**Consultation Response from KC,
Highways Development Management**
2021/92462 rear of, 1091, Manchester Road, Linthwaite, Huddersfield, HD7 5LS
Outline application for erection of detached dwelling
Date Responded: 21/07/21 Responding Officer: J Turner Responding Ref: K1-42/38

This application seeks outline approval for the erection of a detached dwelling at Manchester Road, Linthwaite. All matters are reserved at this stage, so only point of access is considered at this stage.

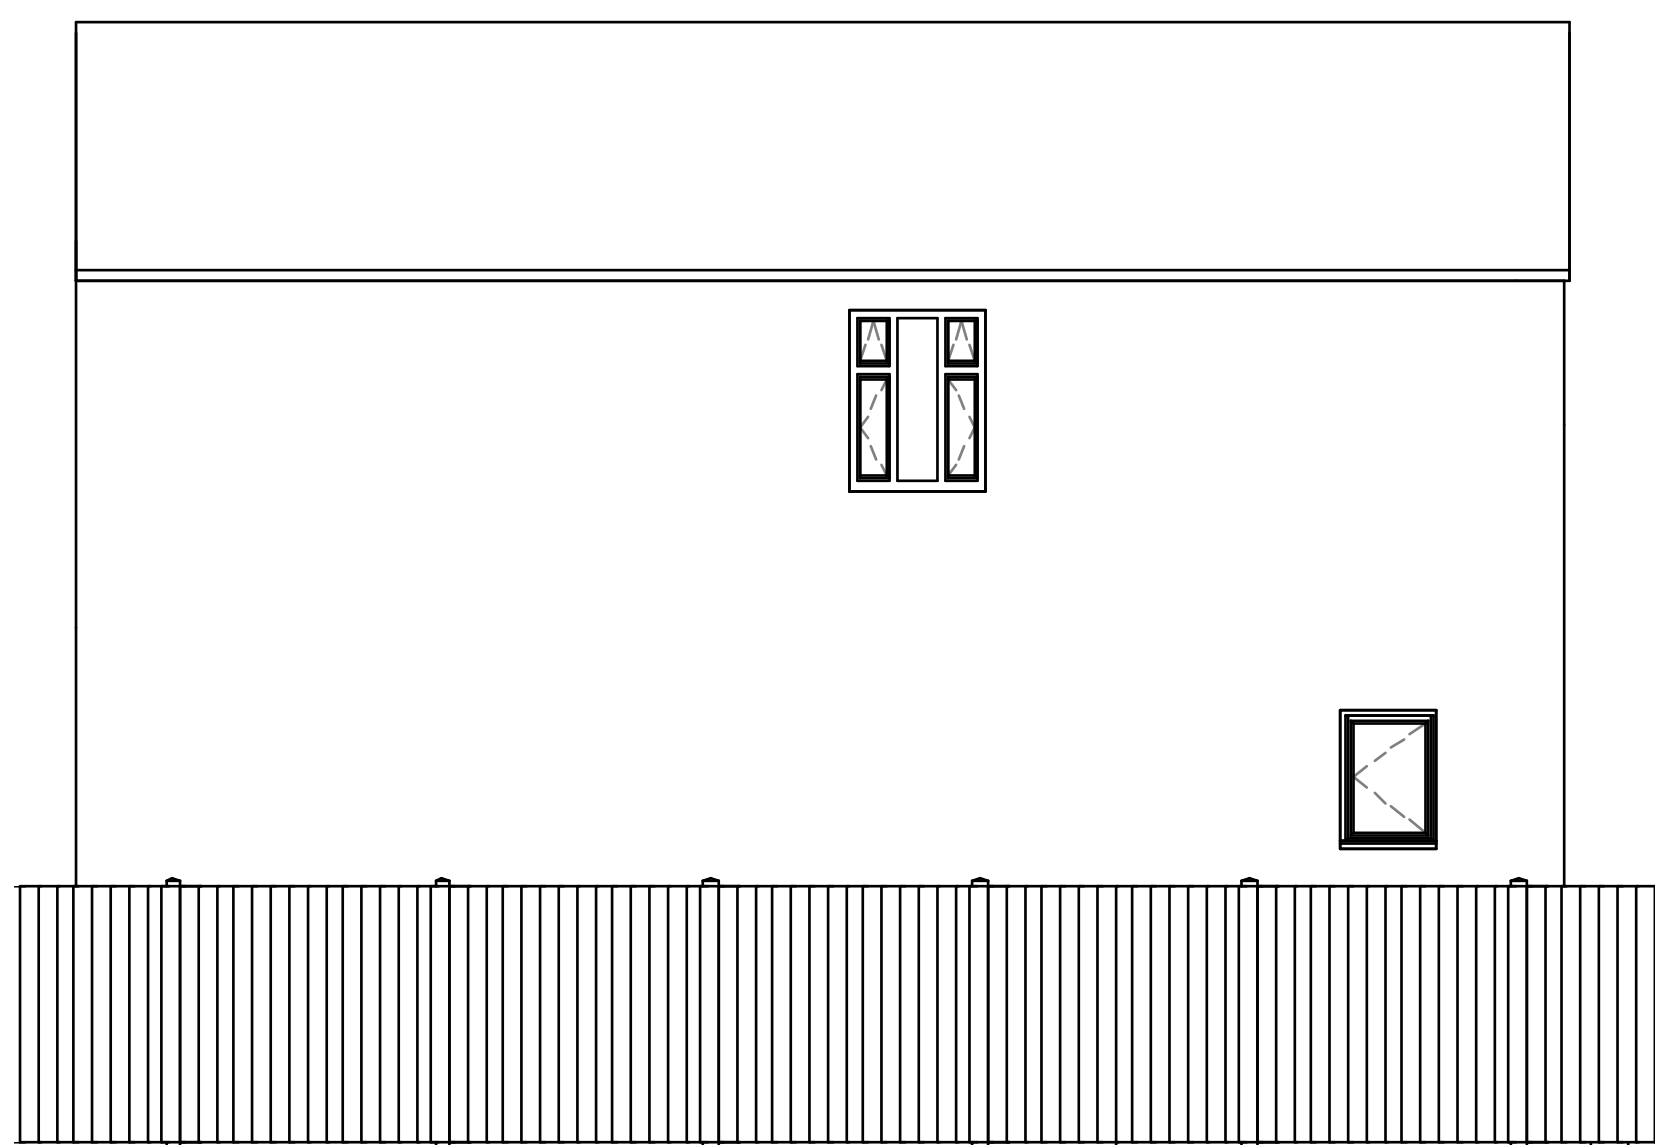
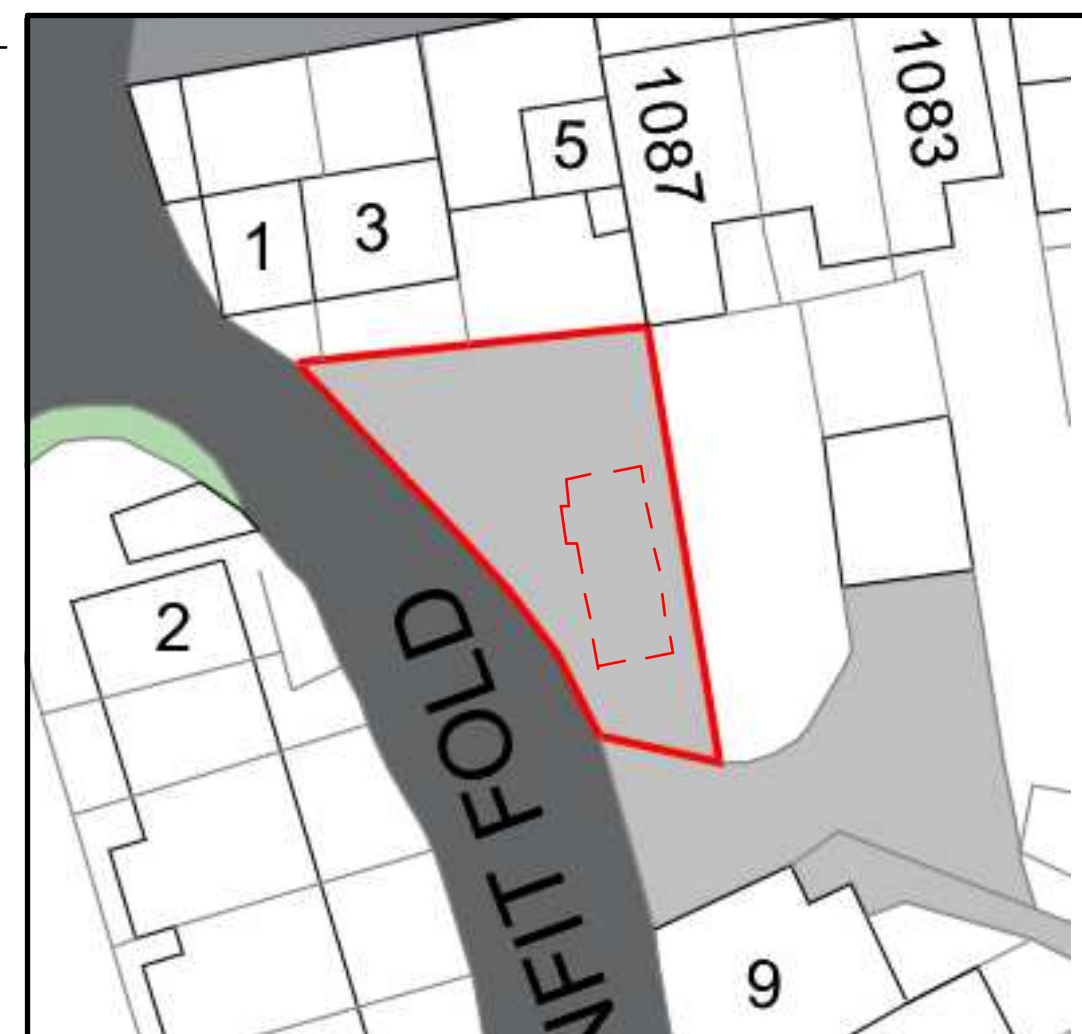
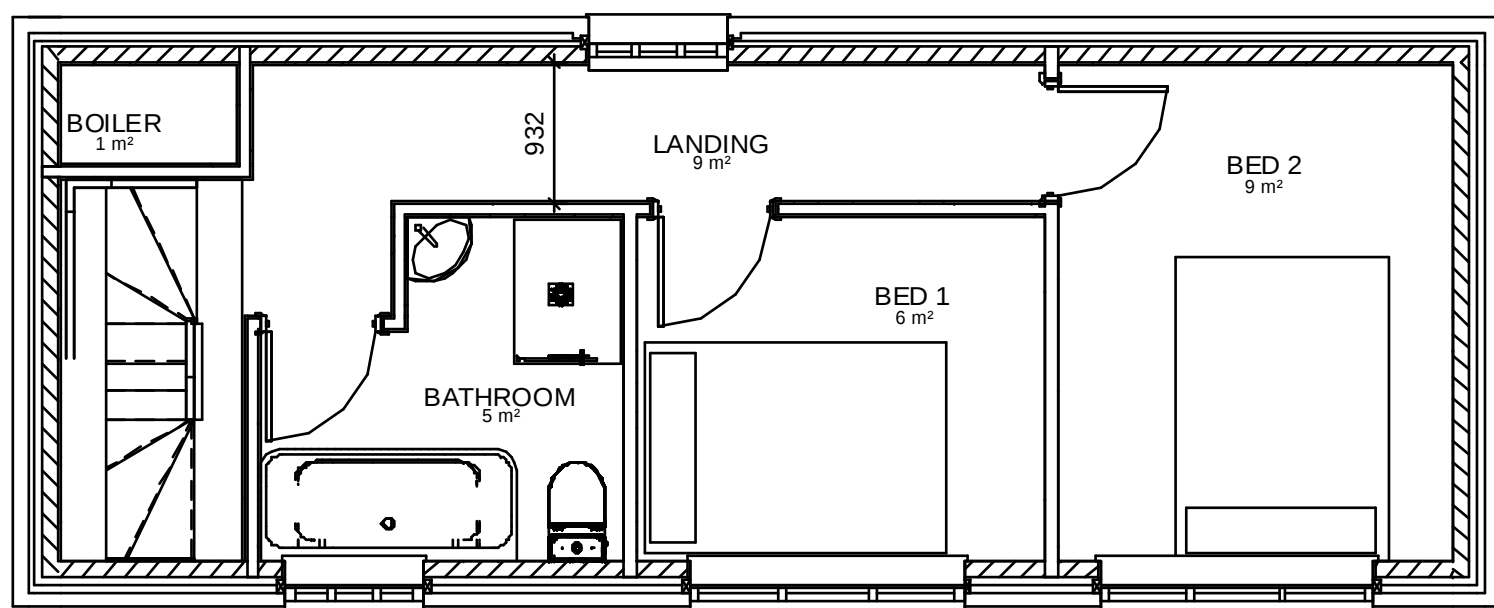
An indicative layout submitted by the applicant shows a two-bedroomed dwelling with two off-street parking spaces provided. Bin storage is also shown, with adequate driveway space to allow for collection from the carriageway edge.

The site takes access onto the public highway via Linfit Fold. Although internal vehicle turning is not provided, the access is taken from Linfit Fold; as this is not a classified highway, it is not essential to provide the ability to access and exit in a forward gear.

The indicative layout is acceptable from a highways perspective, however, the parking arrangement is only suitable for a dwelling of three bedrooms or fewer, so Highways DM would expect this level of living space to be retained should a reserved matters application be forthcoming.

Notwithstanding the details shown on the approved plan, no development shall take place until a scheme detailing arrangements and specification for layout and parking have been submitted to and approved in writing by the Local Planning Authority. Before any building is occupied the development shall be completed in accordance with the details shown on the approved plans and retained thereafter.

No part of the development shall be brought into use until the existing access from Linfit Fold has been permanently closed [and any redundant footway crossings removed and the footway reinstated] and the new access has been constructed and brought into use in accordance with details that have previously been approved in writing by the Local Planning Authority.

The maximum gradient of the access ramp to the car park shall not exceed 1 in 8.
